An
Bord
Pleanála

Board Direction
BD-011958-23
ABP-313362-22

Drawing file: Apartments / 1830-SHD-A-3-200 Apartment Block C Floor Plans, Roof Plan, Section & Elevations.pdf

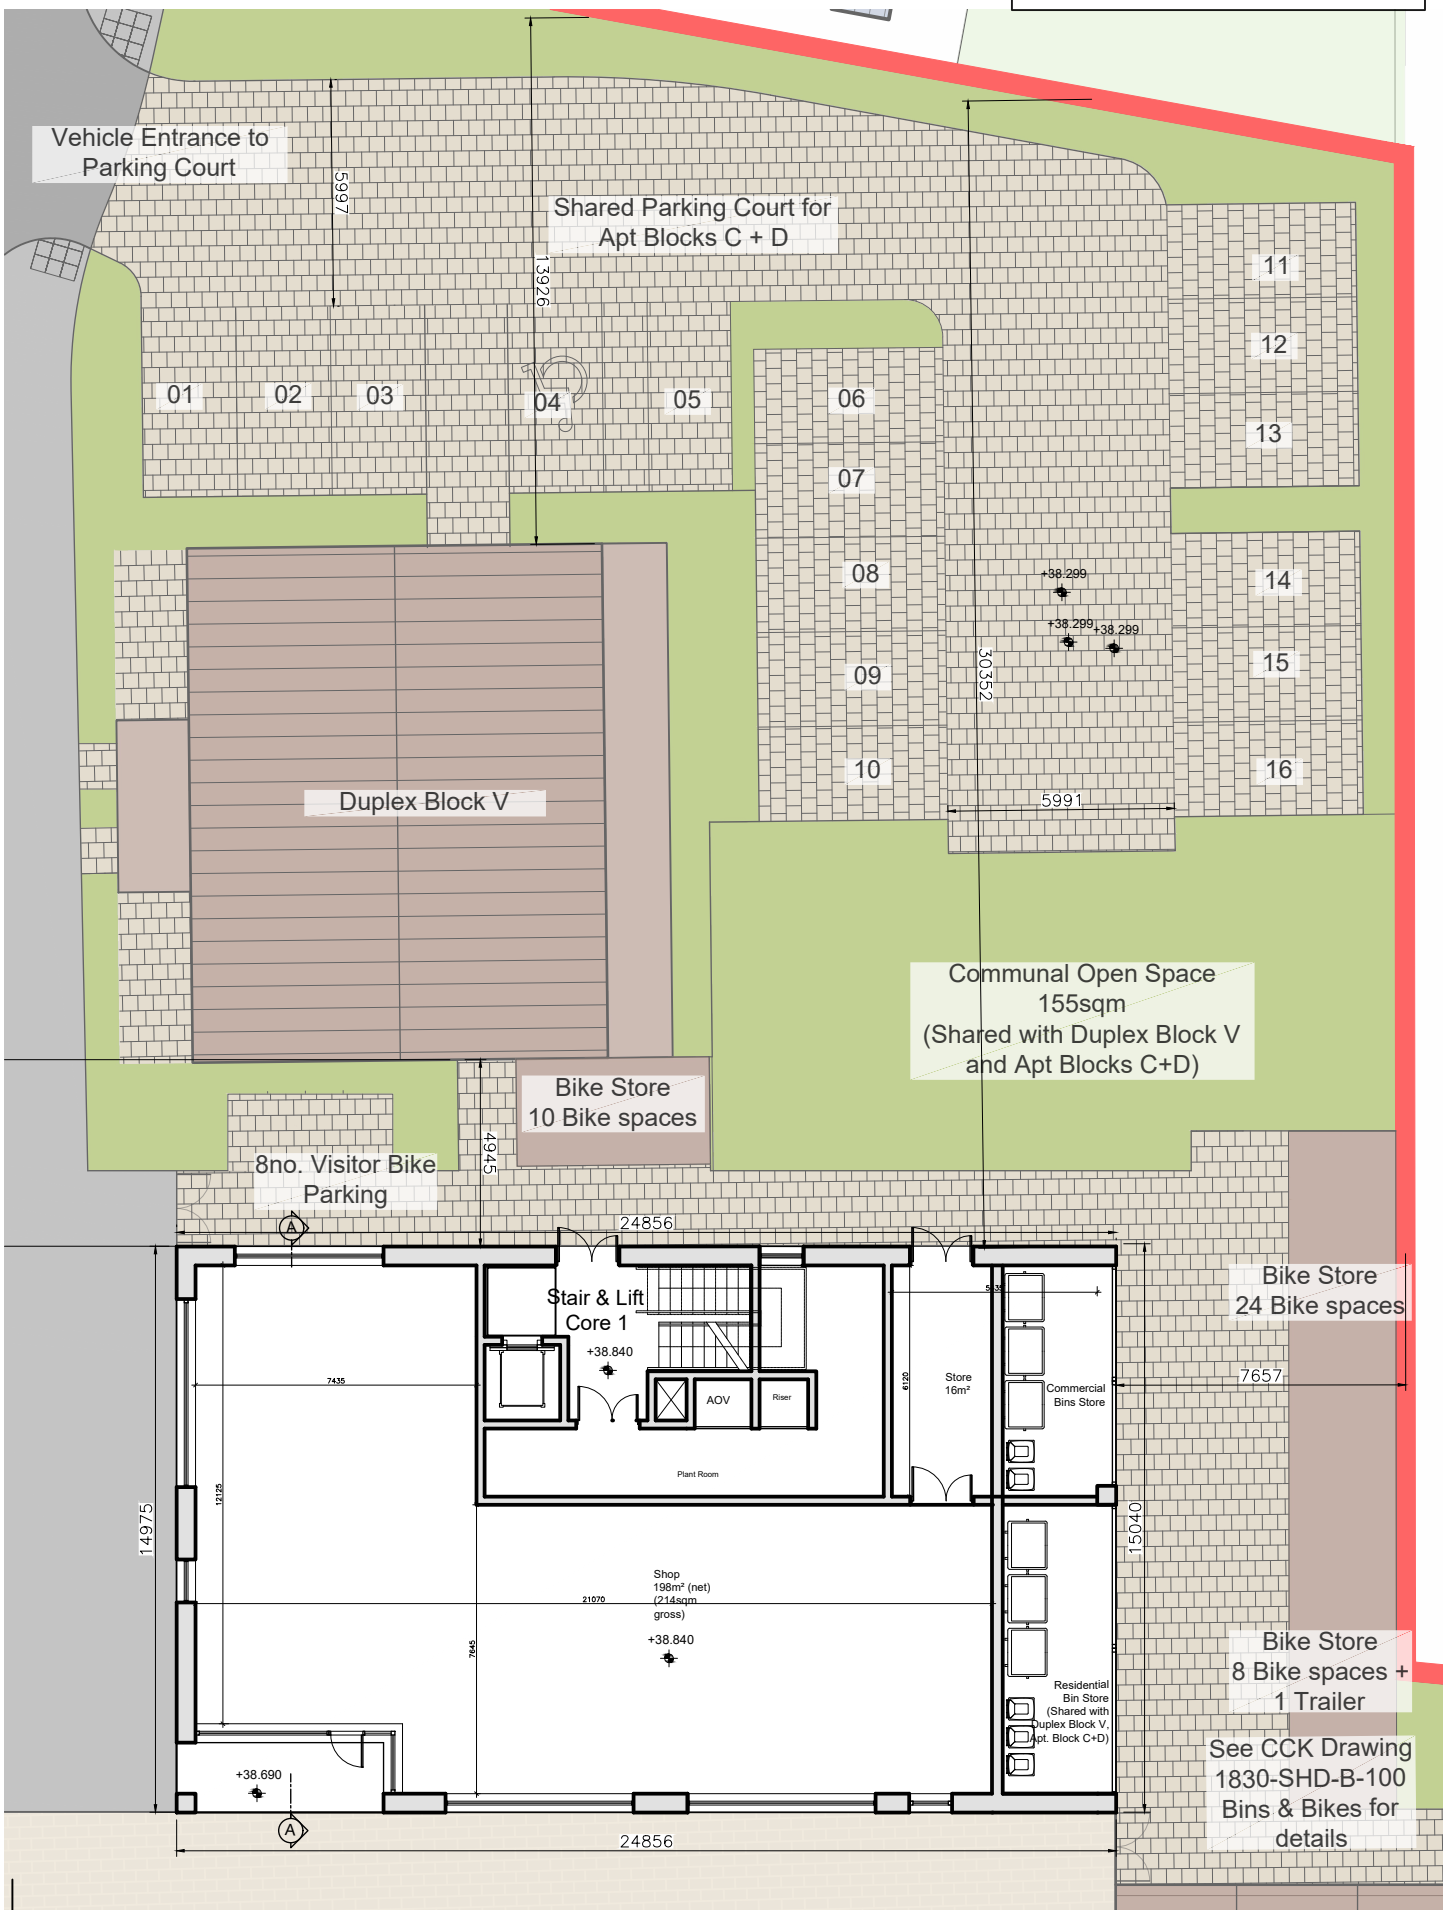
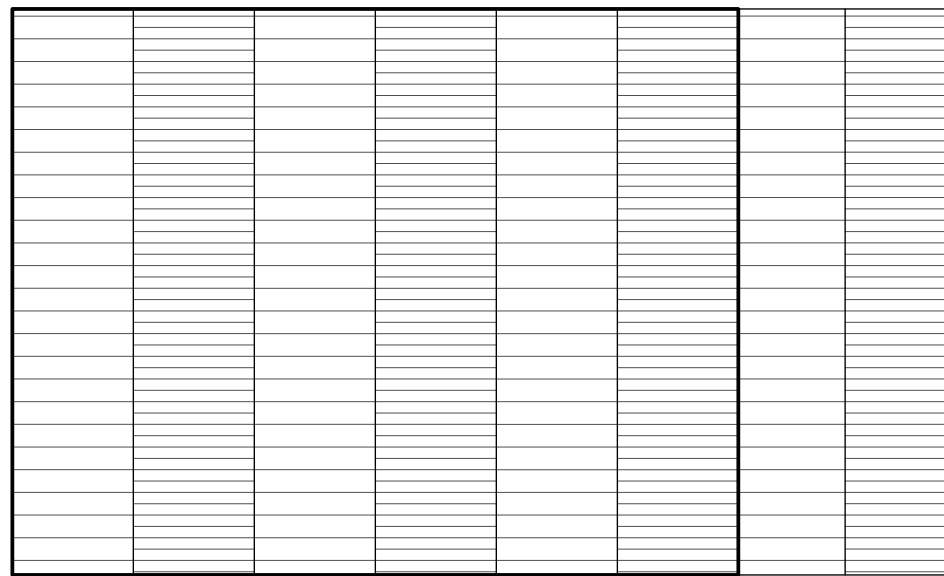
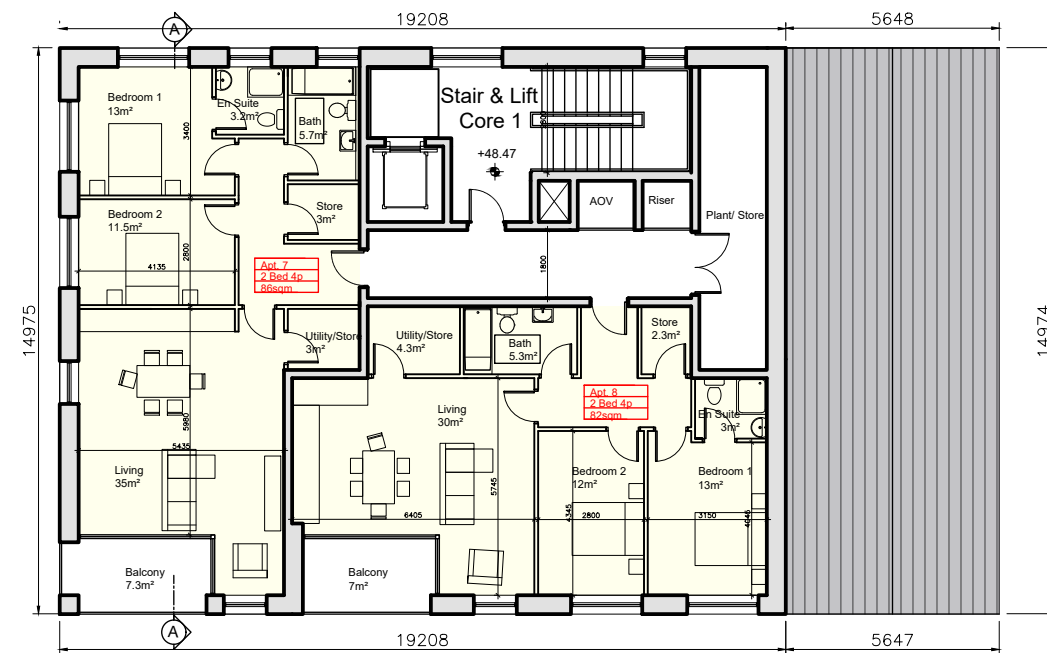
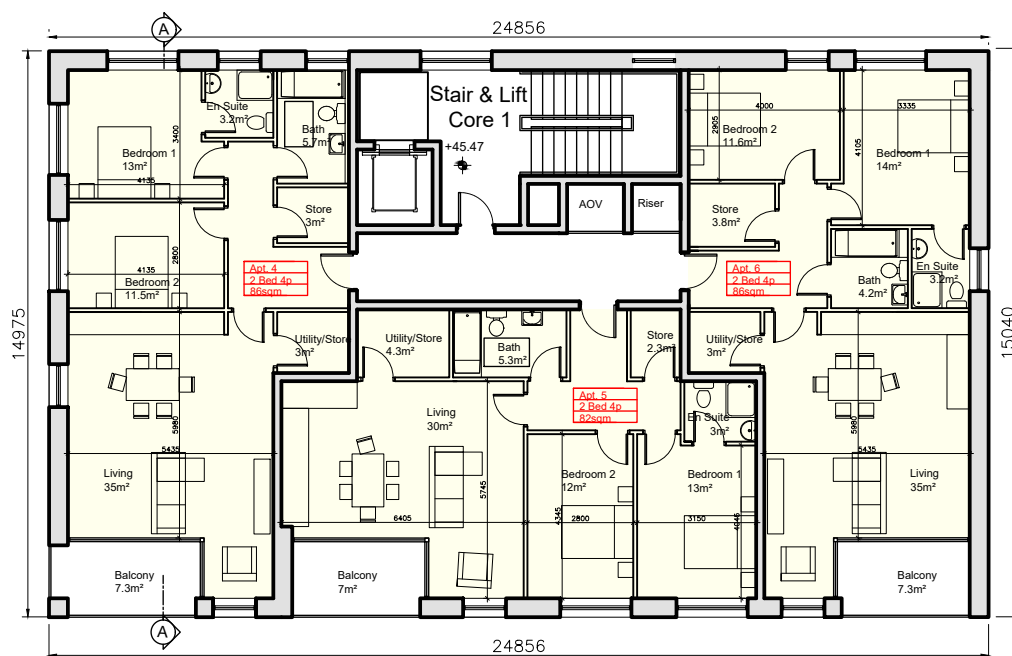
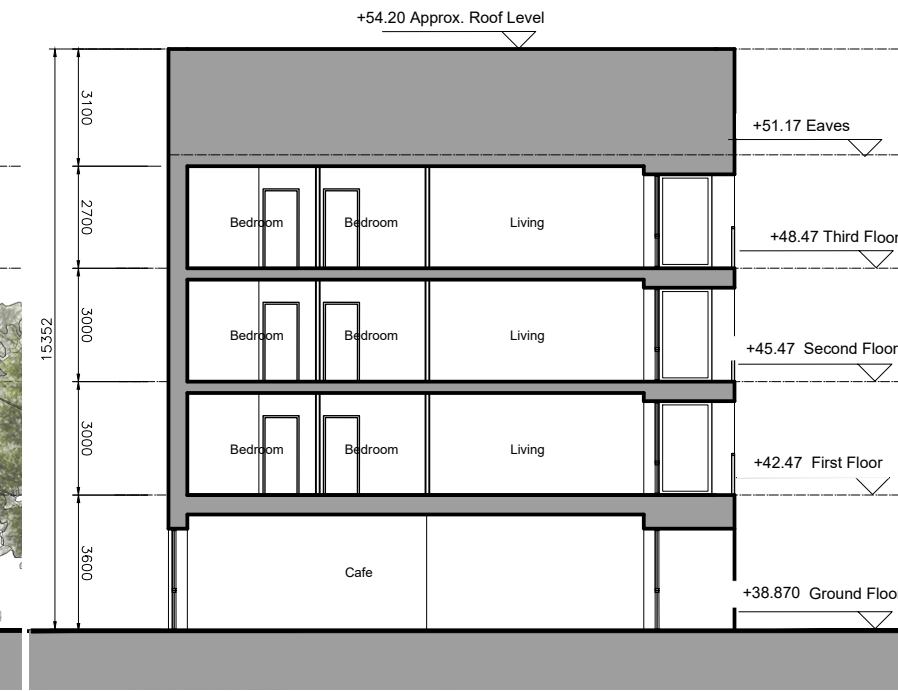
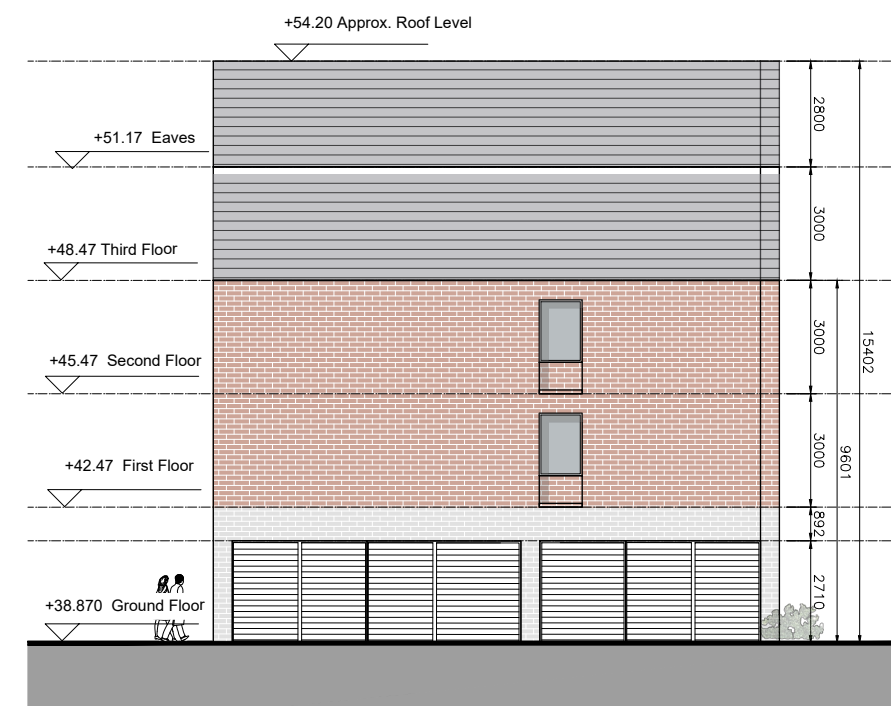
- a) Urban Block 03, which comprises Apartment Blocks B and C and Duplex Block V, shall be omitted and replaced with public open space unless and until such time as permission is granted for future development in this location.
- b) The junction of Road 10/Mooretown Distributor link extension shall be redesigned to cater for walking and cycling access only.
- c) The width of the entrance lobby in Apartment Block E as it adjoins ground floor Unit 3 shall be increased to a minimum width of 1.2m. This may require minor amendments to the design and layout of the Unit 3.

Revised drawings showing compliance with these requirements shall be submitted to, and agreed in writing with, the planning authority prior to commencement of development.
